Re: Request for further information AW/243/25/HH

Subject: Request for further information AW/243/25/HH

PROJECT	226 Manor Way	DATE	15/10/25
TITLE	Elevations	DRG NO	IBA/613/02
SCALE	1 : 100	REVISIONS

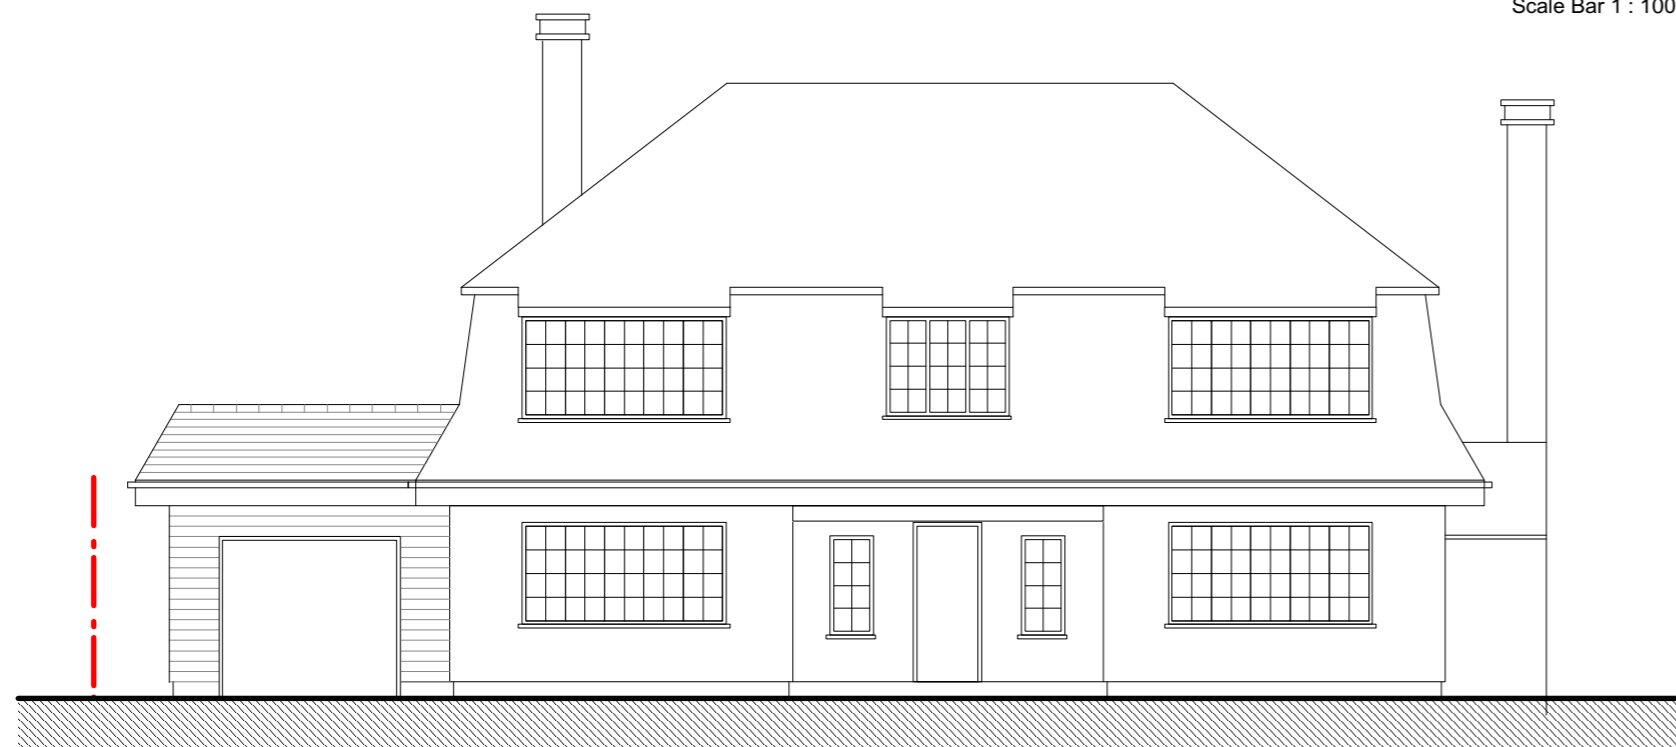
Thank you for your email. Unfortunately the Elevations and the Roof Plan scale bars have been incorrectly labelled as 1:50 when they measure 1:100. Please amend these labels and return at your earliest convenience.
